Application for Planning Permission

Development: Part demolition of boundary wall to form new access to existing site. This application is in CIL Zone 3 (zero rated) as other development and affects the setting of a Listed Building.

Location: Boundary Wall To Nyton House Nyton Road Westergate PO20 3UL

Site Plan
showing proposed works

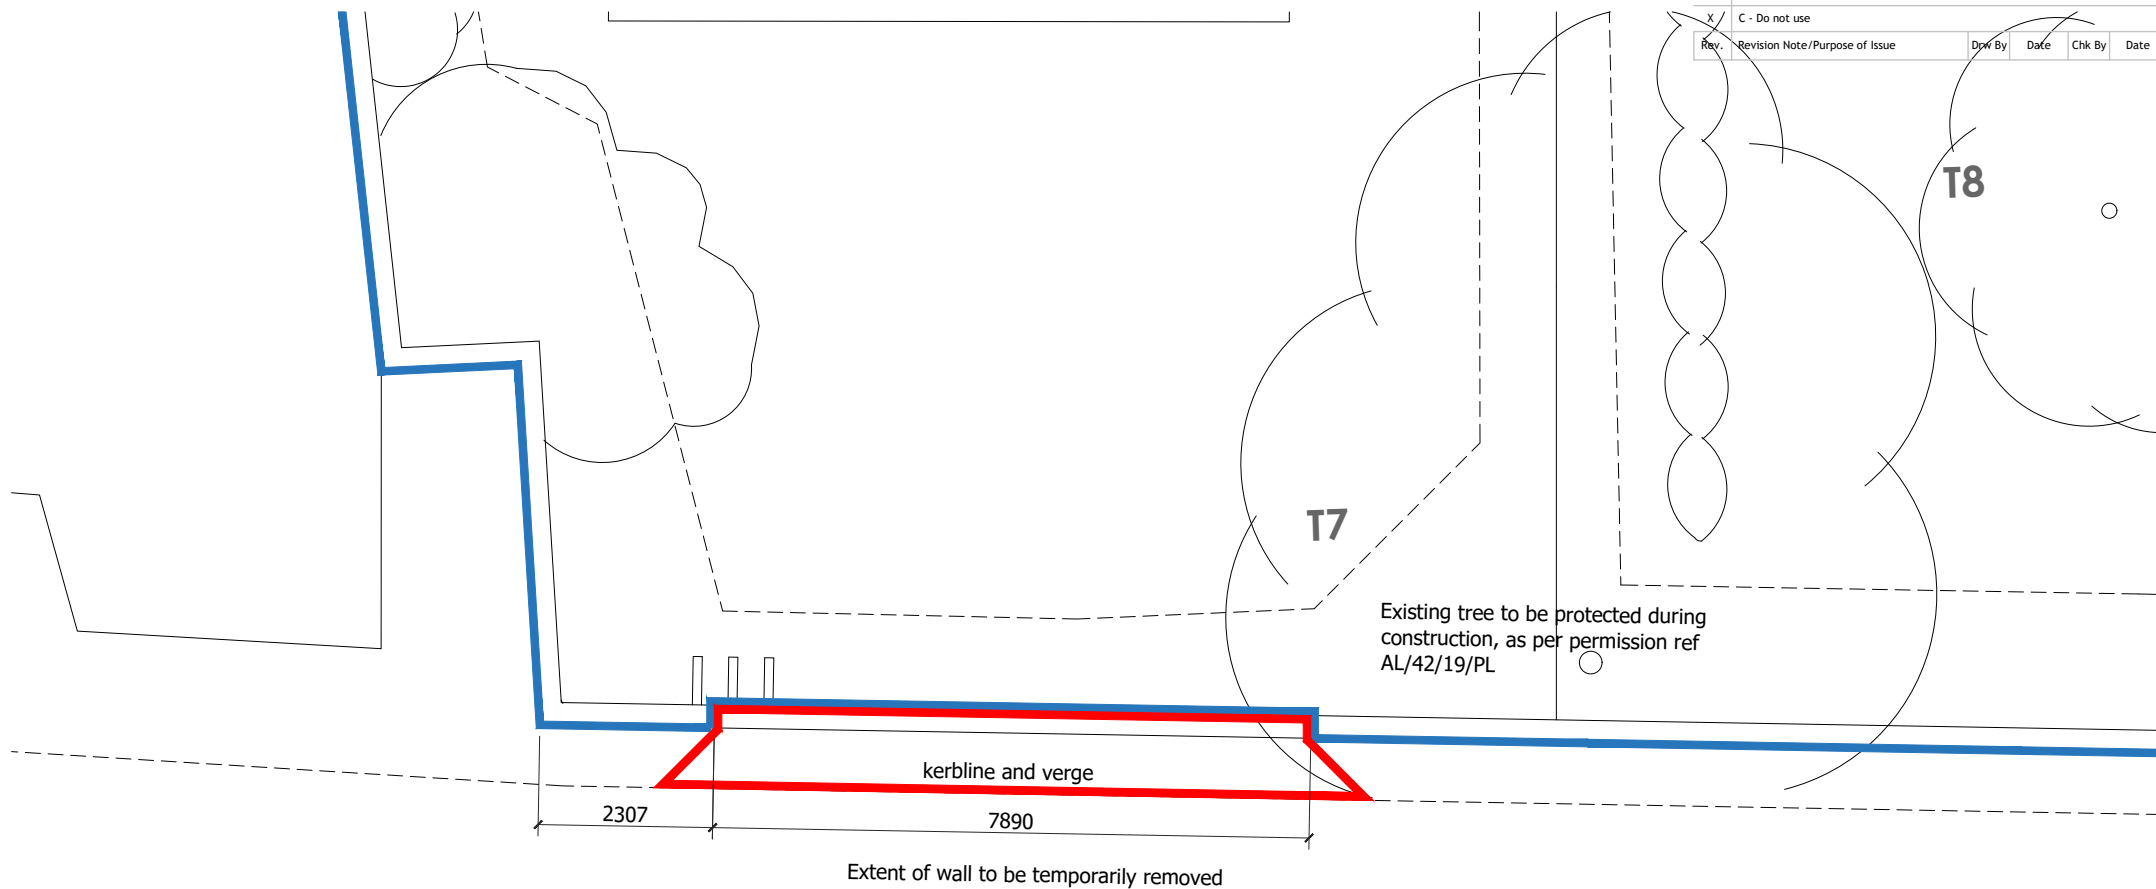
Visibility Splay

West Sussex County Council require that a visibility splay is provided. A splay is formed for a 30 mph speed limit road by measuring from a point 2.4m back from the kerb edge in the centre of the proposed access. A line should then be drawn from either side of this point for 43 m in each direction to the nearside edge of the carriage way. The splays must intersect and only within the control of the applicant, or within the publicly maintained highway.

The distance will increase with the speed limit of the road. If the road is 40 mph speed limit then the distance should be 120 m either side. For speeds above this please contact West Sussex County Council Highways for advice on what would be acceptable.
